OXFORDSHIRE COUNTY COUNCIL'S RESPONSE TO CONSULTATION ON THE FOLLOWING DEVELOPMENT PROPOSAL

Application no: 23/01493/REM

Proposal: Reserved Matters Application including access, layout, landscaping and scale pursuant to outline planning permission 14/02121/OUT for internal primary and secondary streets along with the partial discharge of conditions 12 (Building for Life 12), 16 (means of vehicular access), 17 (means of pedestrian/cycle links) and 19 (detailed surface water drainage scheme) for Phase 1B

Location: Proposed Himley Village North West Bicester, Middleton Stoney Road, Bicester

OS NORTH

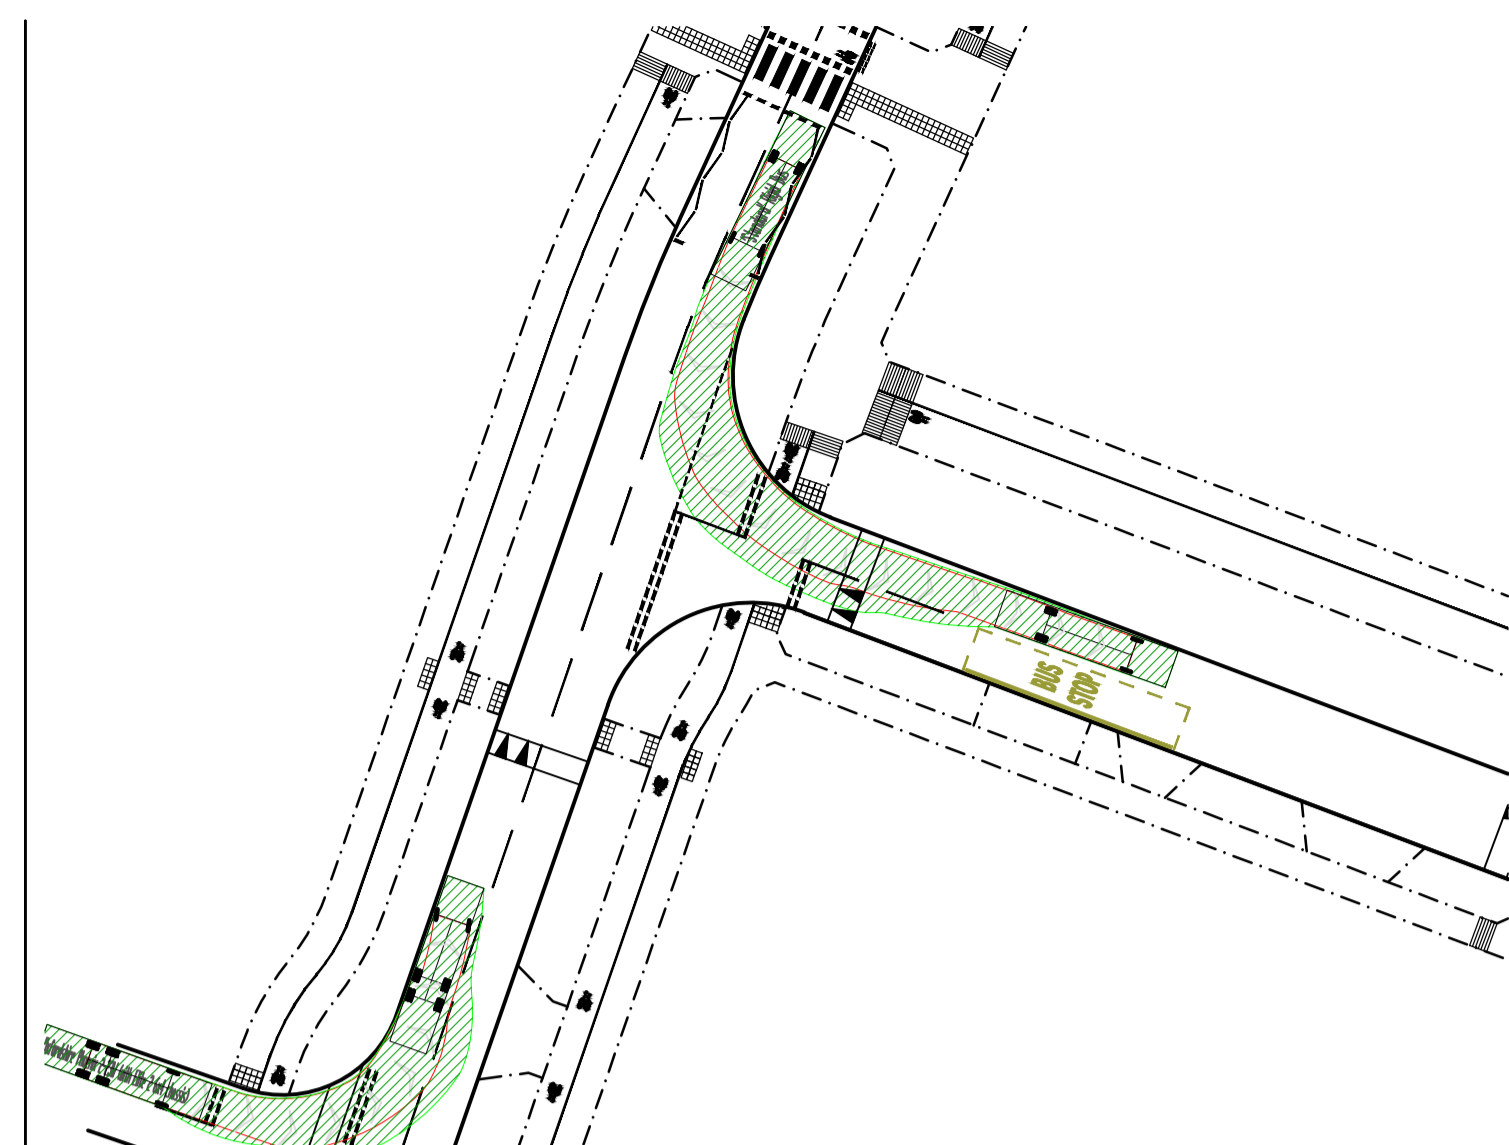
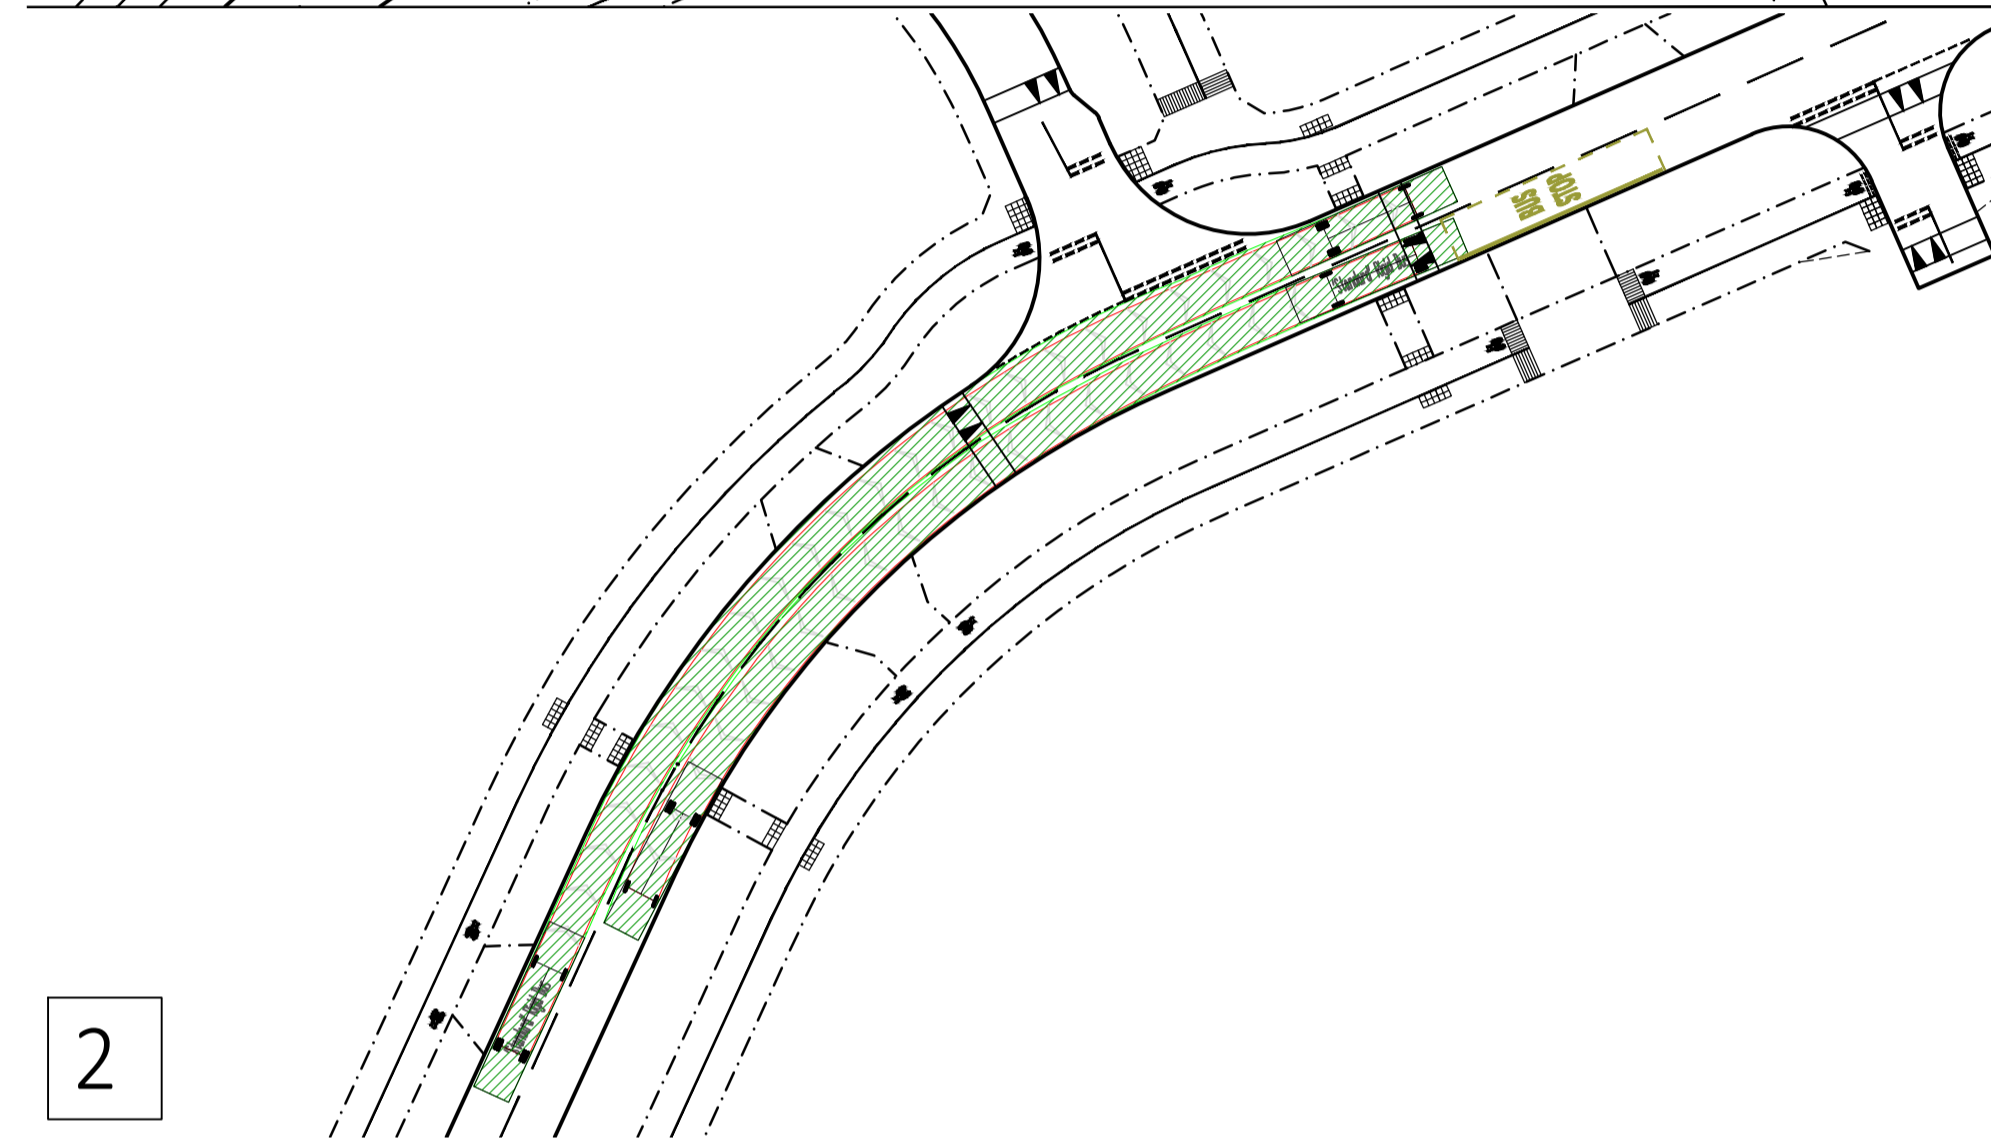
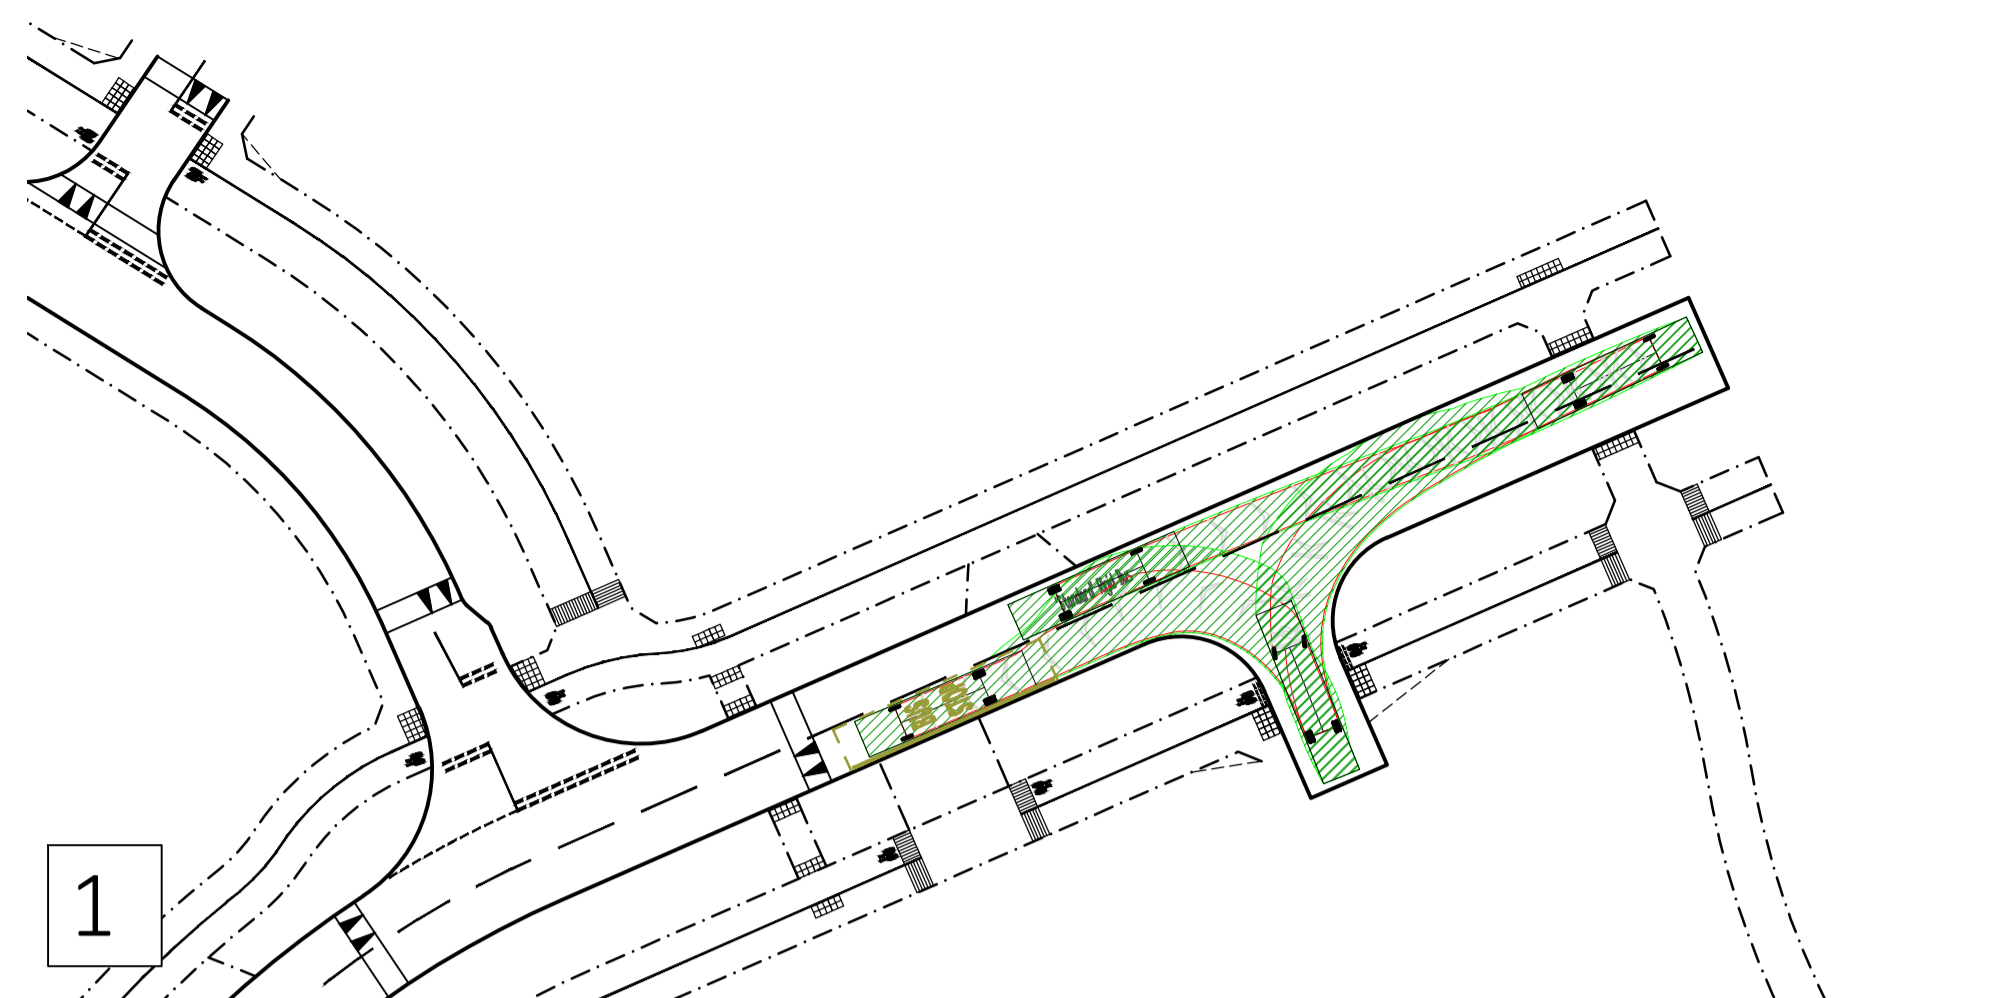
I previously explained that the temporary bus turning heads were not acceptable as it would require buses reversing over the raised cycle crossings. After discussions with the applicant, it has been agreed that the raised cycle crossings at the northern end of the Spine Road North - South and at the eastern end of the Spine Road East - West will be implemented when Oxfordshire County Council have confirmed that the requirement for the use of the temporary bus turning heads has ceased.

In addition, the raised crossings at the western end of the strategic secondary streets will be implemented when these roads connect to Phase 3 and Oxfordshire County Council have confirmed that the temporary turning heads are no longer required. Insets on the Engineering Layout Sheets 1 to 4 include the layout of all the temporary turning head as well as the agreed final layout.

In accordance with the approved Phase 1B Engineering Layout Sheets 1 to 4 (dwg nos 27141-HYD-1B-XX-DR-C-2200/P09, 27141-HYD-1B-XX-DR-C-2201/P10, 27141-HYD-1B-XX-DR-C-2202/P10, 27141-HYD-1B-XX-DR-C-2203/P09) works associated with the temporary bus turning heads shall be constructed and remain in place until Oxfordshire County Council have confirmed that the temporary turning heads are no longer required. The final road layout as shown on the approved plans, including raised tables and all road markings, shall be completed within 6 months of the final use of the temporary turning heads unless otherwise agreed in writing with the Local Planning Authority.
